Your ref:	Bershka - 221/223 Oxford Stre...	Please reply to:	Mr Gregor Gault
Our ref:	24/01094/ADV	Tel No:	
		Fee Queries:	0207 641 6500;
		Email:	planningreception@westminster.gov.uk;
Mrs Lucy Palac Deploy Project Services 28 The Ridgeway Tonbridge TN10 4NH United Kingdom		Incomplete Applications Town Planning & Building Control City of Westminster PO Box 732 Redhill, RH1 9FL	
		26 February 2024

TOWN AND COUNTRY PLANNING (CONTROL OF ADVERTISEMENTS) (ENGLAND)
 REGULATIONS 2007

Address: Alexandra House, 221-223 Oxford Street, London, W1D 2LJ,

Proposal: Display of nine vinyls on glazing measuring 2.2m x 2.23m, 2.2m x 2.73m, 3.96m x 4.03m, 3.96m x 4.97m, 3.96m x 4.24m, two measuring 2.2m x 2.22m, and two measuring 2.2m x 2.74m for a temporary period from 08 April 2024 to 31 August 2024.

IMG_SEC_SHT_Fachada Calle-Street Façade 1
1 : 50

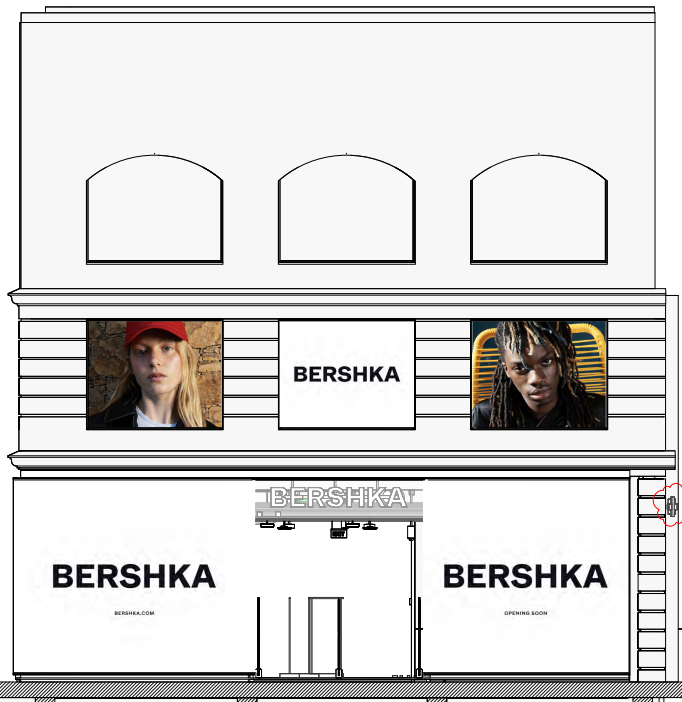
- existing elevation drawing.
- updated proposed elevation drawing featuring a scale bar and titling / reference number.

Your plans and drawings must be accurate and drawn to a recognised metric scale, include a scale bar, with any precise dimensions stated for important details. You must give each plan a distinctive reference number.
